**RE: Holy Cross Townhomes
Grading and Drainage Plan
Stamp 11-20-2015 (File: E19D021A)**

Re: DRB Project 1006844, Holy Cross Townhomes, Grading & Drainage

This letter is in response to the November 5, 2015 DRB Comments for the Grading & Drainage plan for the Preliminary Plat for the Holy Cross Townhomes.

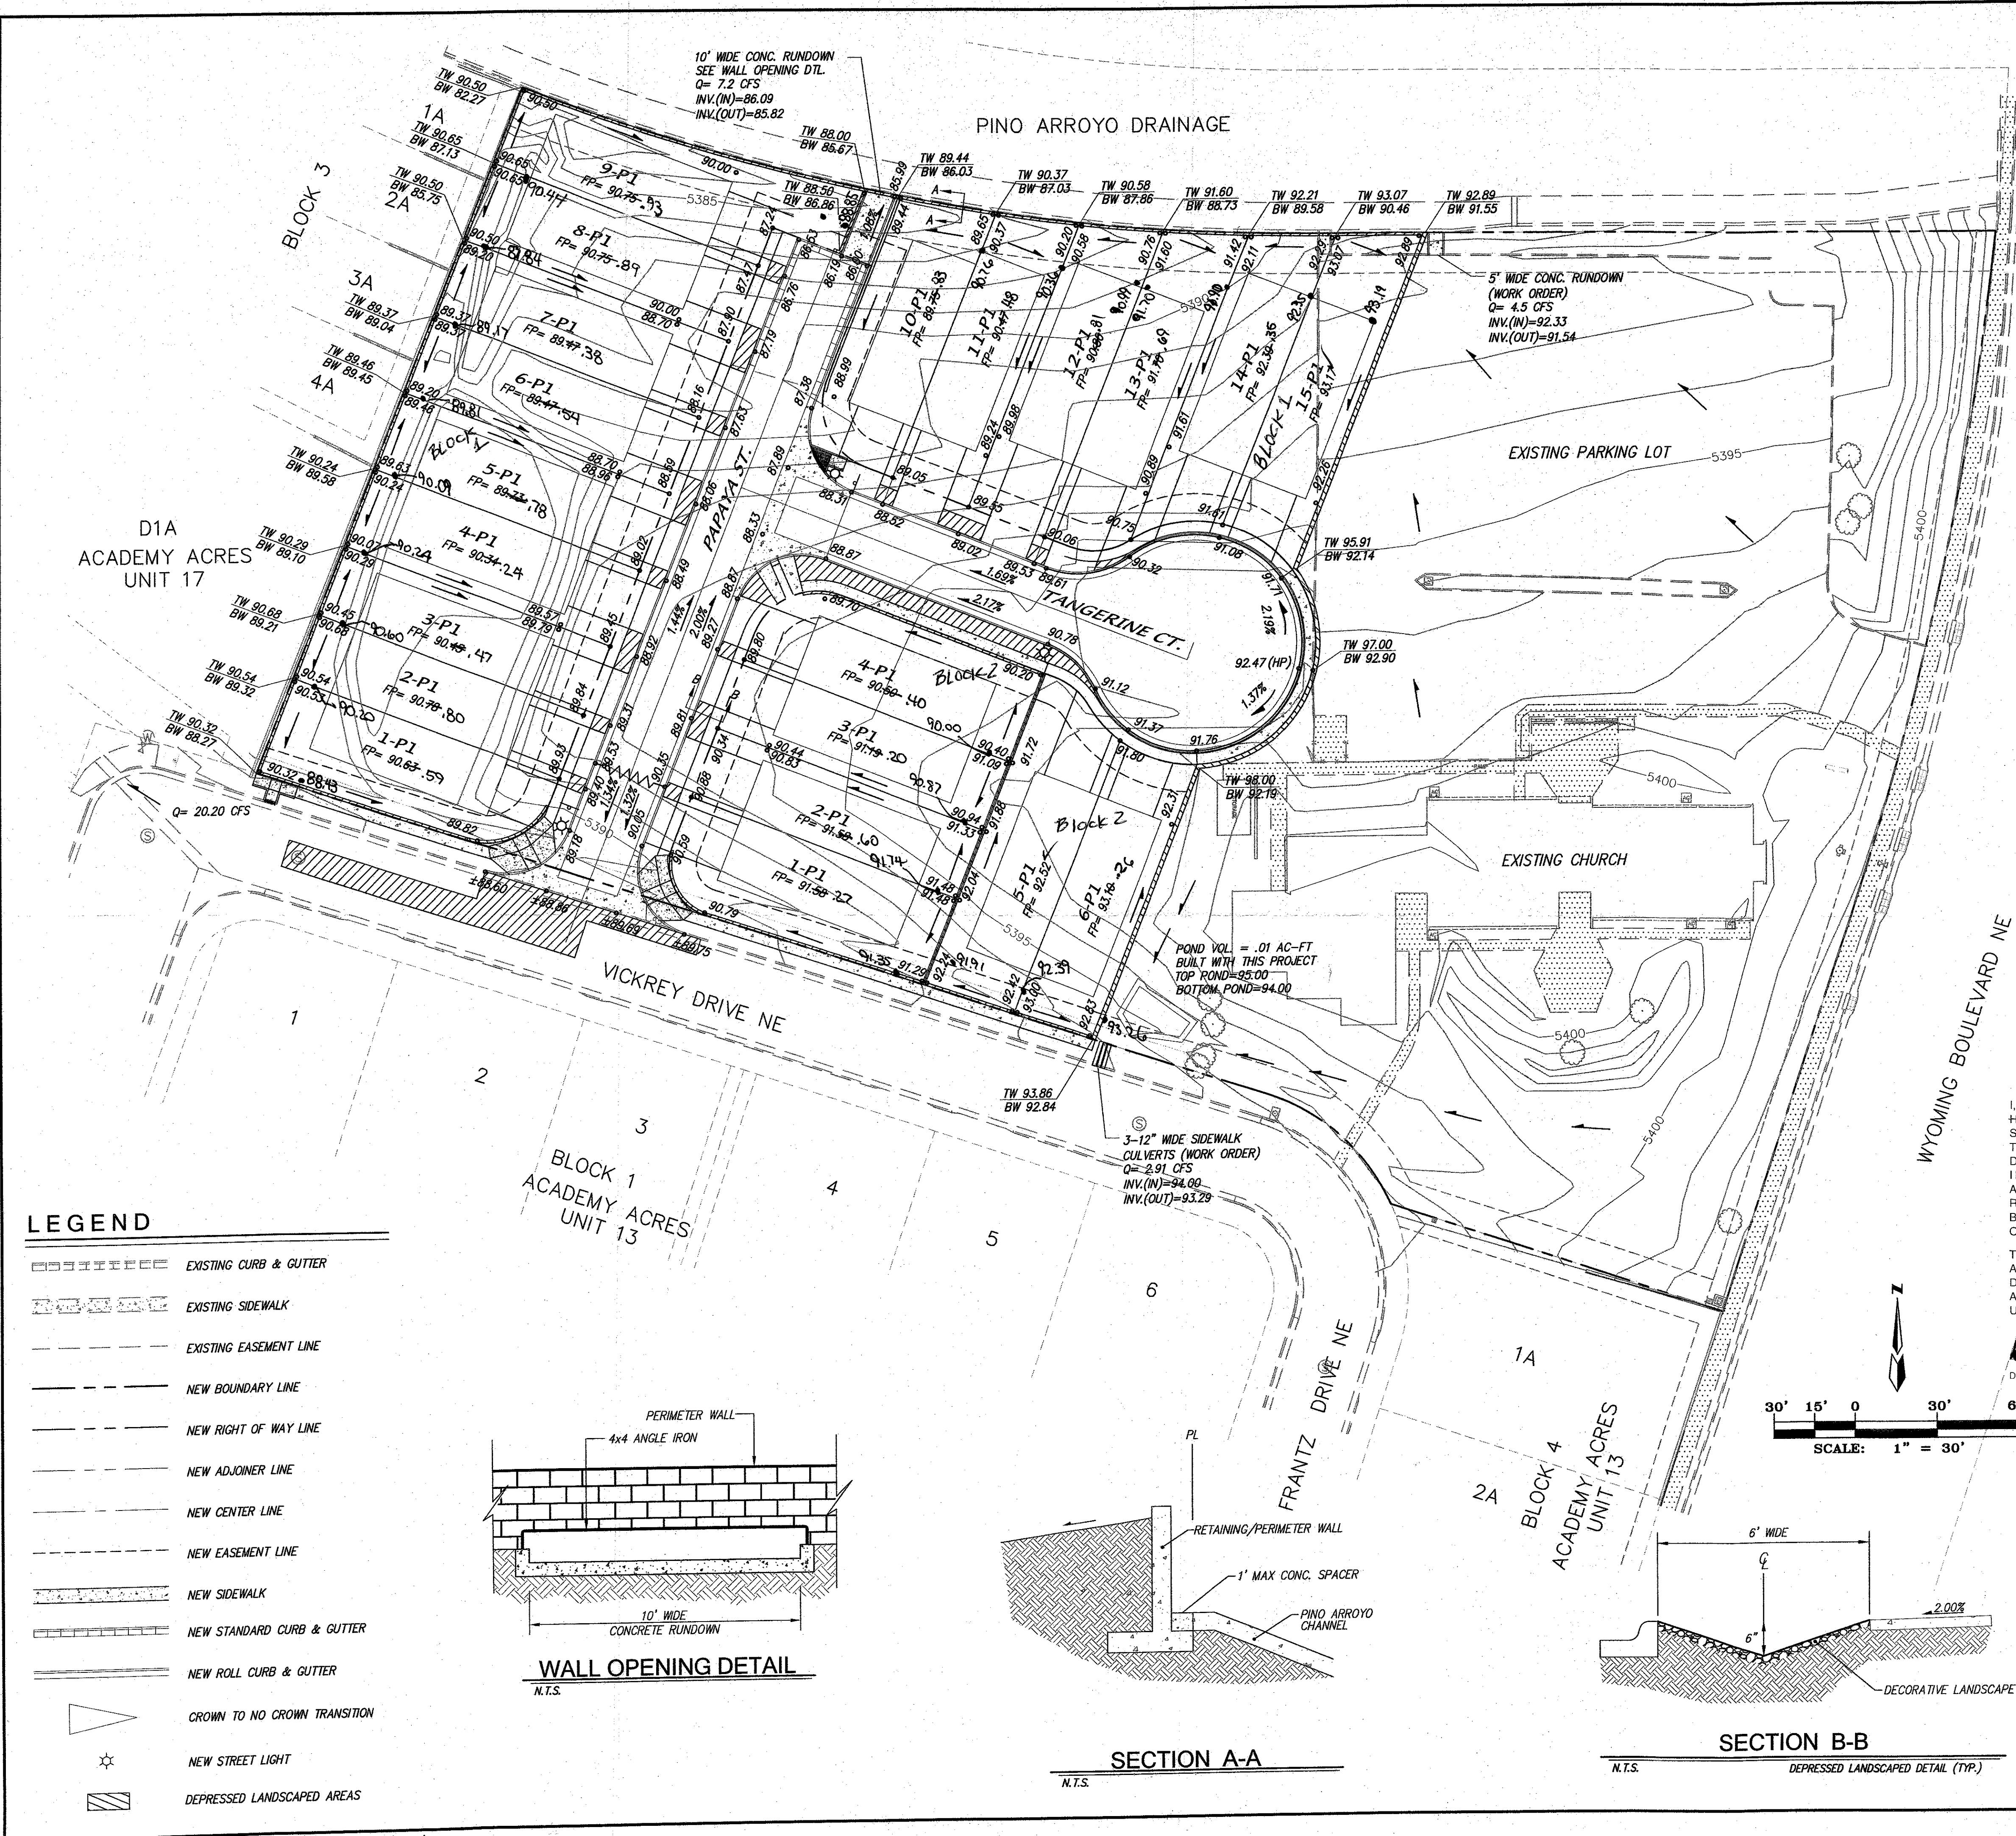
- A first flush retention method needs to be included. It appears that the proposed plan included depressions between the sidewalk and the curb which could serve the purpose, but the drainage report states that the first flush requirement will not be addressed. If the depressions shown on the plan are to be used, a calculation of the first flush required vs. provided needs to be included. If the depressions proposed between the sidewalk and the curb are not sufficient, then the design needs to include ponding areas on the individual lots.

- These items will be including in a separate Infrastructure List for the adjacent property.
- Analysis Point 6 (AP^Λ) in Vickrey Dr. is shown with a discharge of 10.06 cfs in Figure 1, but labeled with a discharge of 20.20 cfs t the valley gutter in the same vicinity on the Grading and Drainage Sheet.

- Previous platting and design documents reference a rundown on the NW corner of the existing site. If this structure exists, it needs to be noted on the sheet.

- We agree and have noted this on the sheet.
- Show the dimensions of the wall opening on the design sheet.
 - We agree and have noted this on the sheet.

- We agree and have included the design calculations.
- The concrete rundown on the north end of the adjacent property and the sidewalk culverts shown on Vickrey Dr. cannot be listed on the infrastructure List for the "Holy Cross Townhomes" property. It needs to be 1) constructed as a condition of final plat approval, 2) included in the Infrastructure List for the adjacent property improvements, or 3) revert to the original lot line configuration that does not separate the property as a separate lot until the rundown and culvert are constructed.

- The 10.06 cfs shown in Figure 1 is accounting for the street flow within Vickrey Dr and contributing flows from the project. The 20.2 cfs shown on the grading plan is the total flow out falling into the valley gutter from the Holy Cross site and the flows from the Academy Acres Unit 13 site below the project site.
